Portland Fire Department  
Fire Prevention Bureau  
380 Congress St  
Portland, ME 04101

#### NOTICE OF INTENT TO PROSECUTE

An inspection of the property located at 86 Quebec St on June 09, 2015 revealed that the structure and premises fail to comply with NFPA 2009 Fire Code and/or NFPA Life Safety Codes. Attached is a list of those violations.

**Inspection Violations**

Existing 2nd Flr. Hall/stair

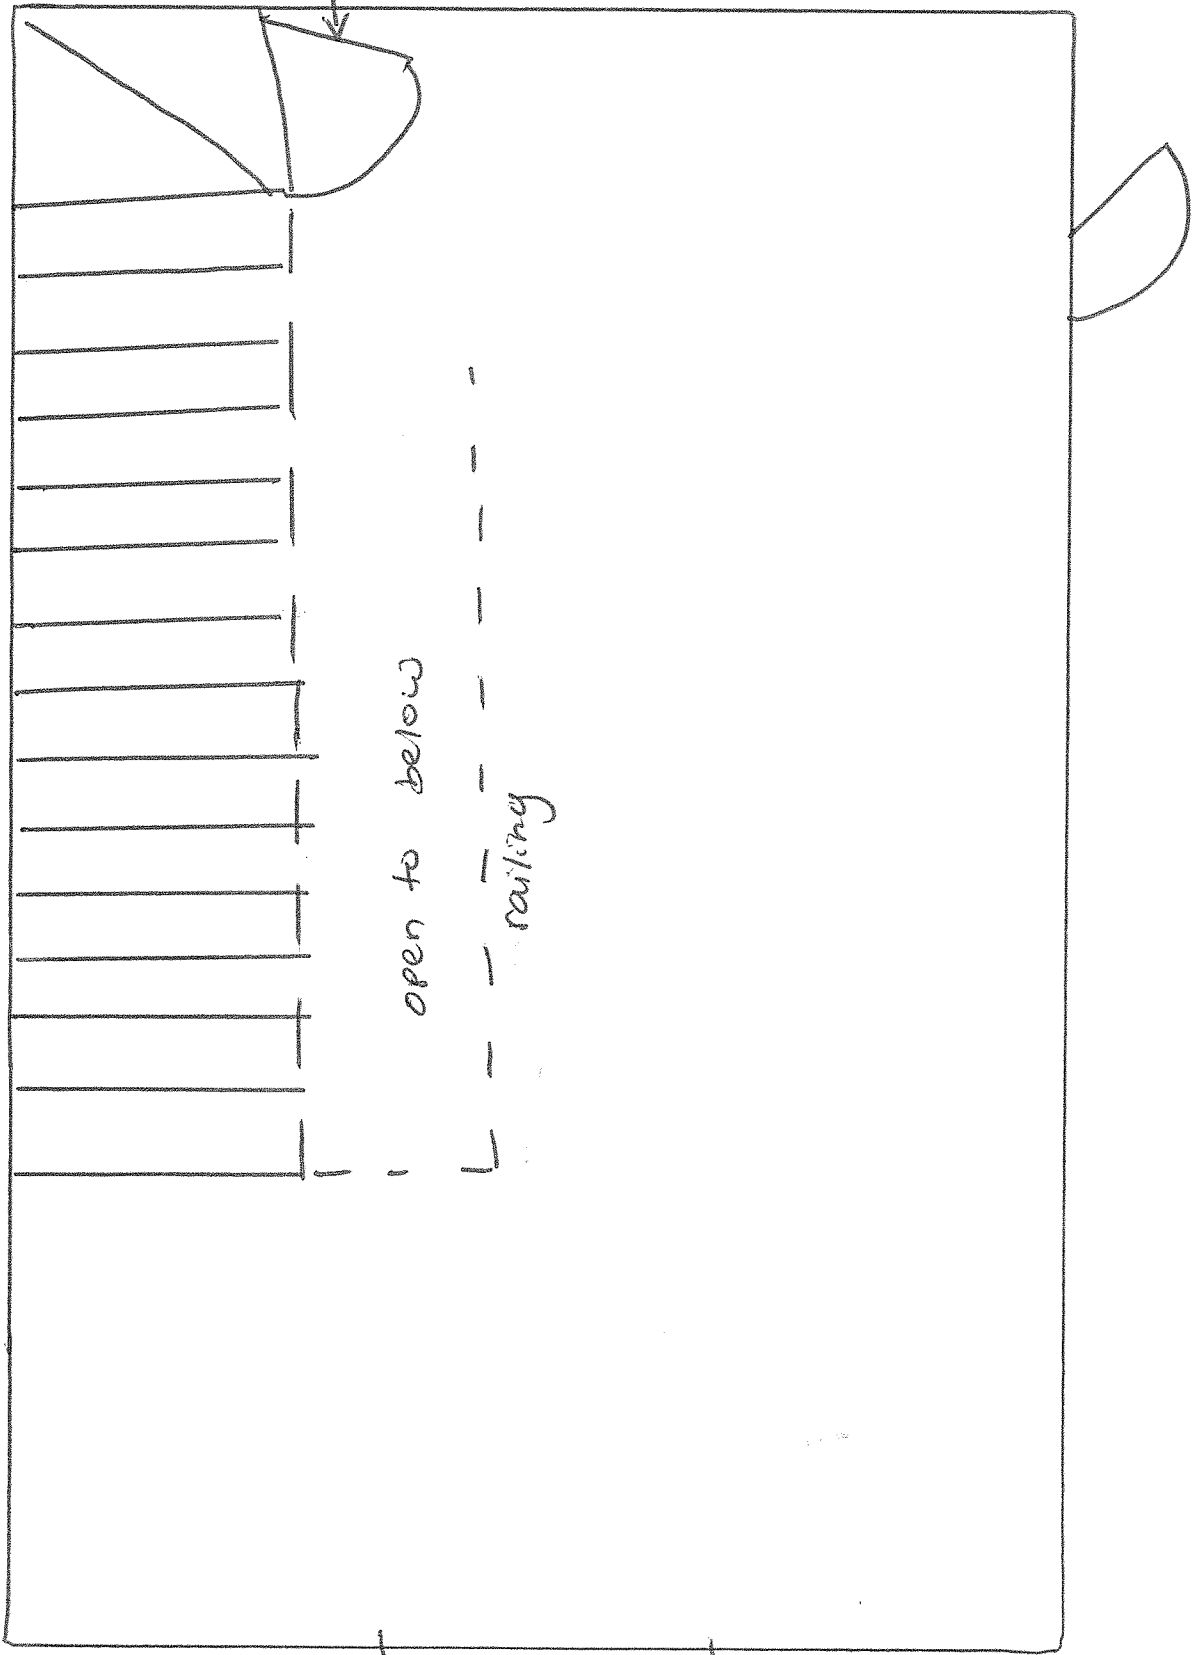
**Violation:** NFPA 101-7.2.4.3.1 FIRE BARRIER REQUIRES MAINTENANCE; Fire barriers separating buildings or areas between which there are horizontal exits shall have a minimum 2-hour fire resistance rating, unless otherwise provided in 7.2.4.4.1, and shall provide a separation that is continuous to the finished grounded level.

**Notes:** REAR STAIRWELL HOLES

**Violation:** NFPA 31.3.1.1.1 VERTICAL OPENINGS NOT FIRE RATED; VERTICAL OPENINGS SHALL BE ENCLOSED OR PROTECTED IN ACCORDANCE WITH SECTION 8.6.

**Notes:** REAR STAIRWELL 2ND FLOOR CEILING

**Violation:** NFPA 101- 7.5.1.1.1 SECOND EXIT REQUIRED; Where exits are not immediately accessible from an open floor area, continuous passageways, aisles, or corridors leading directly to every exit shall be maintained and shall be arranged to provide access for each occupant to no less than two exits by separate ways of travel, unless otherwise provided in 7.5.1.1.3 and 7.5.1.1.4.

**Notes:** THIRD FLOOR APARTMENT ONLY 1 STAIRWELL SERVICING UNIT
